## **SSD 6011 - Mixed use residential development within the South West Plot**

**Submission by:**

**Paul Dexter and Judith Kavanagh**

**28 July 2013**

## Winter Solstice (21<sup>st</sup> June)

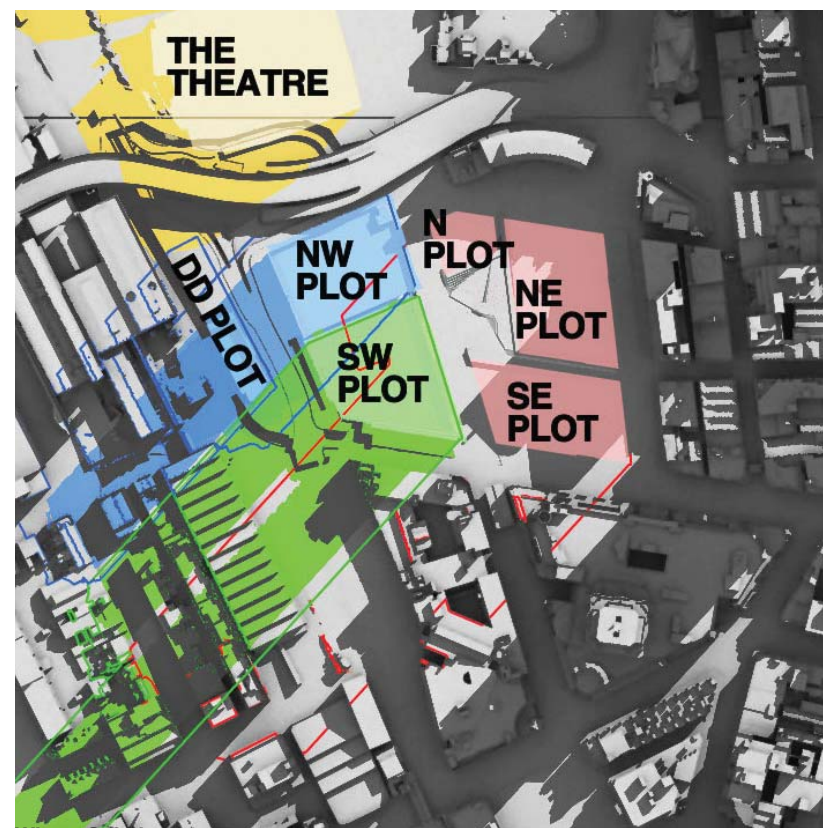
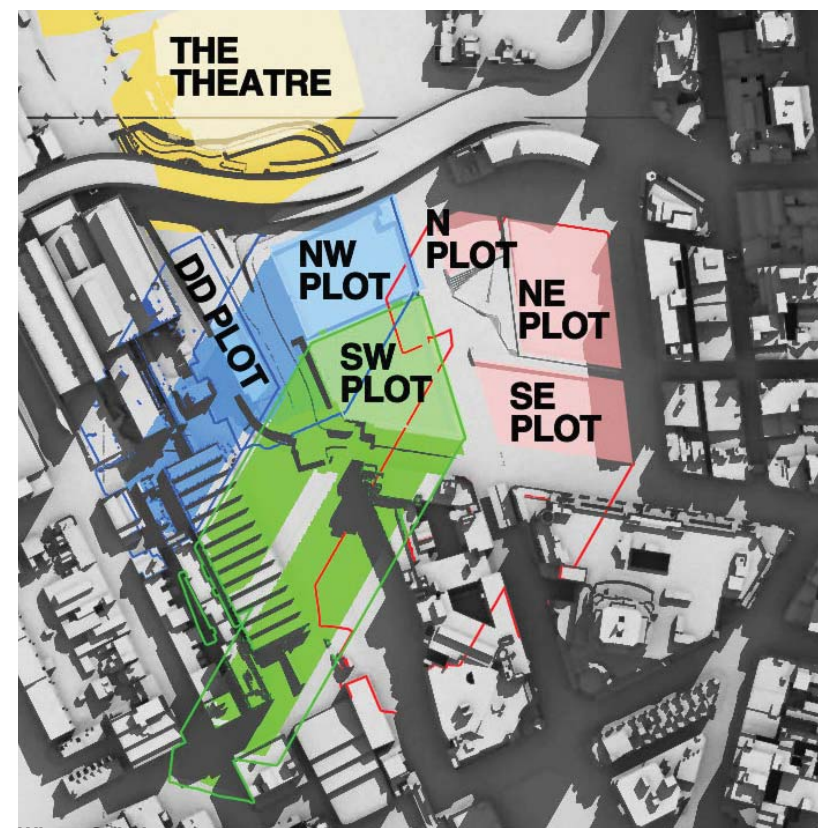
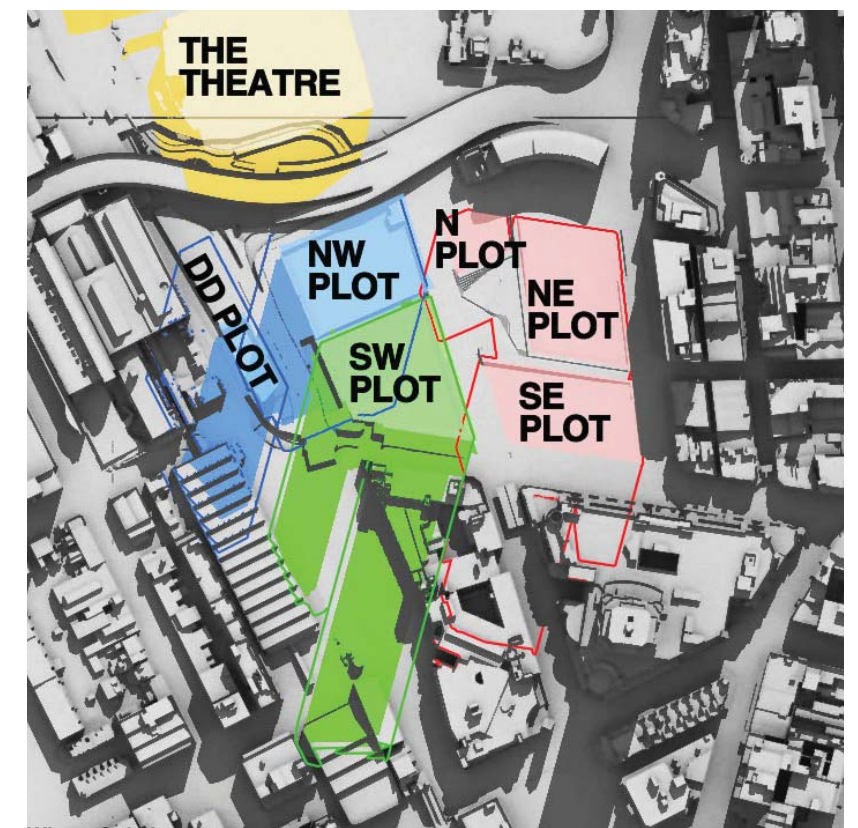
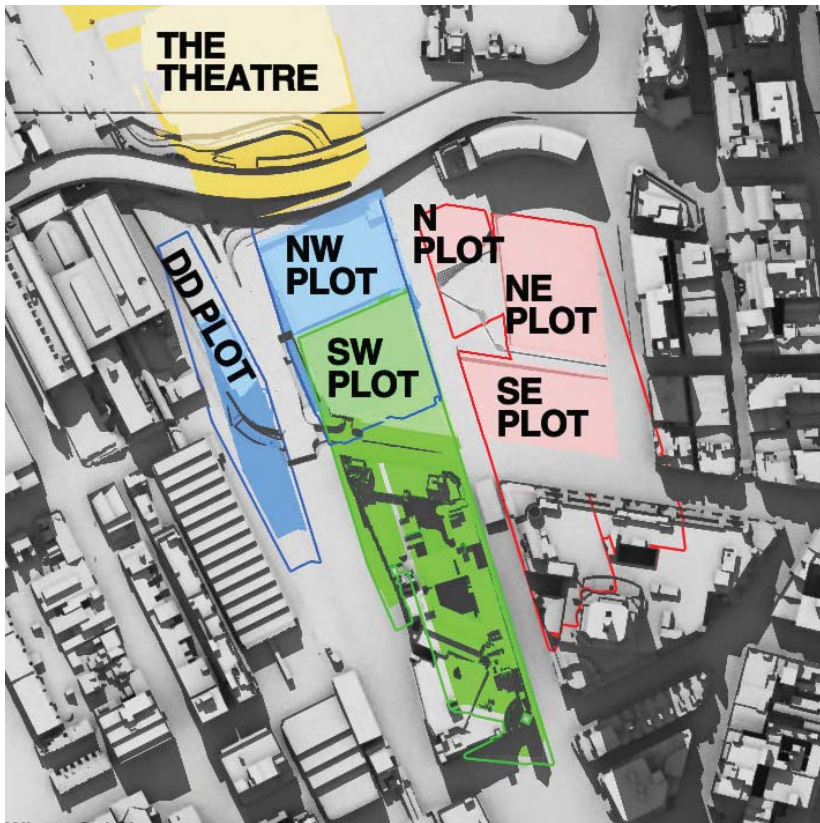
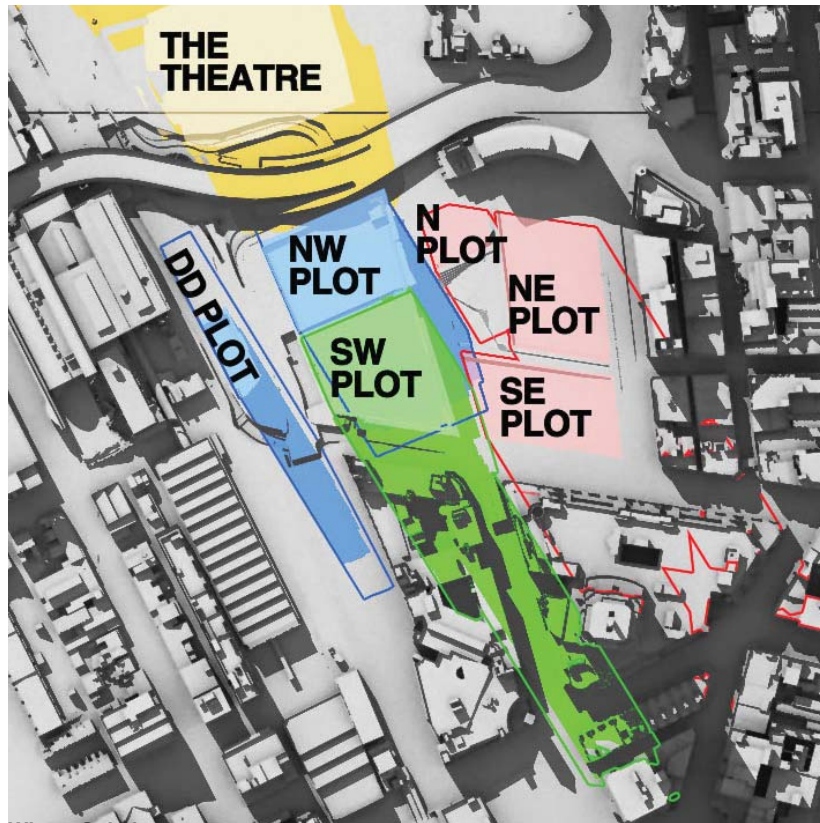
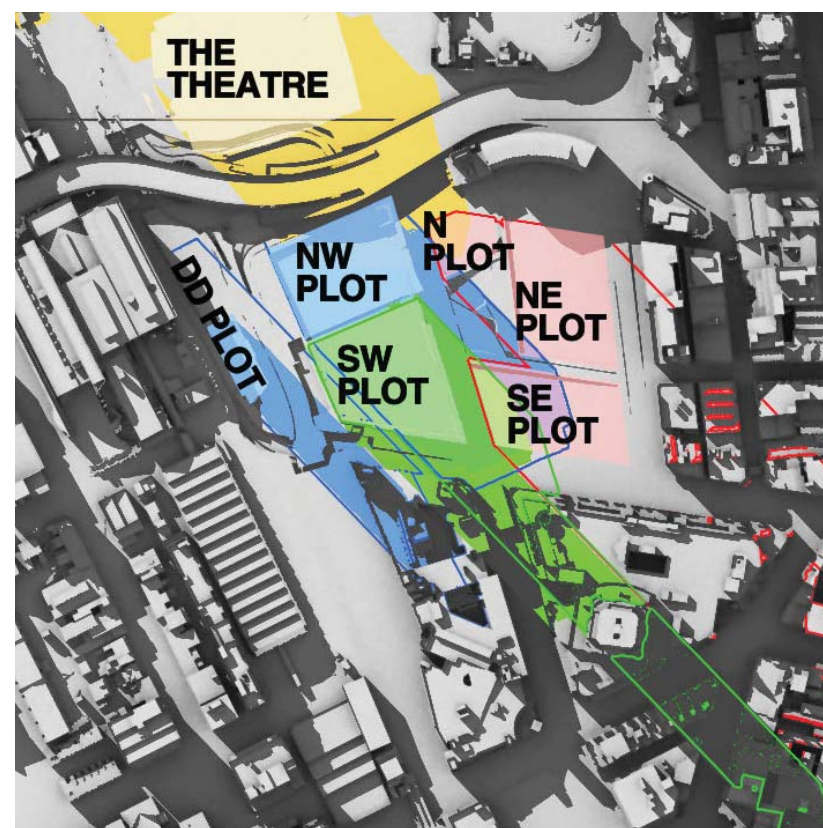
We refer to the shadow diagrams in SSD5878, Appendix H. Supplementary Design Report, Section 6. Amendments, Winter solstice - 22 June. This is not 21 June, but there would be no noticeable difference.

At 9am, 10am and 11am the west façade is totally in shadow due to other parts of The Peak building itself.

At 12pm there is still substantial existing shadowing on the west façade caused by the irregular shape of the west facade.

At 1pm the existing shadowing has been substantially removed, but not totally removed.

It can be concluded that some single aspect apartments on the west façade and some south-west dual aspect corner apartments currently receive less than 2 hours direct sunlight to habitable rooms and 50% of the private open space between 9am and 3pm on 21 June.

By 2pm the existing shadowing has been totally removed, but that is too late to achieve two hours of direct sunlight before 3pm.

At 9am, 10am and 11am the west façade is totally in shadow due to other parts of The Peak building itself.

At 12pm there is still substantial existing shadowing on the west façade caused by the irregular shape of the west facade.

At 1pm the existing shadowing has been substantially, although not entirely, removed. However, overshadowing of lower levels of the west façade by the concept proposal parameter plan shadows for the N,NE and SE plots has already started.

By 2pm the existing shadowing has been totally removed. However, overshadowing of the west façade by the SSDA4 and SSDA5 buildings has appeared and risen further up the west façade than the concept proposal parameter plan shadows for the N,NE and SE plots, which is still present.

At 3pm, the proponent states correctly that 45-45% of the western façade is overshadowed by the SSDA4 and SSDA5 buildings.

It can be concluded that, as a result of combination of the proposed development with existing shadowing of the west façade, some single aspect apartments on the west façade and the south-west dual aspect corner apartments which currently receive less than 2 hours direct sunlight to habitable rooms and 50% of the private open space between 9am and 3pm on 21 June will suffer additional overshadowing. It is beyond our skills to count the number of such apartments. We note that the proponent has made no attempt to do so.

Rather than counting the number of units which will not meet the DCP guidelines, the proponent attempts to trade-off direct sunlight at 4pm for lack of direct sunlight during the period 9am to 3pm. There is no provision in the DCP guidelines for such a trade-off.
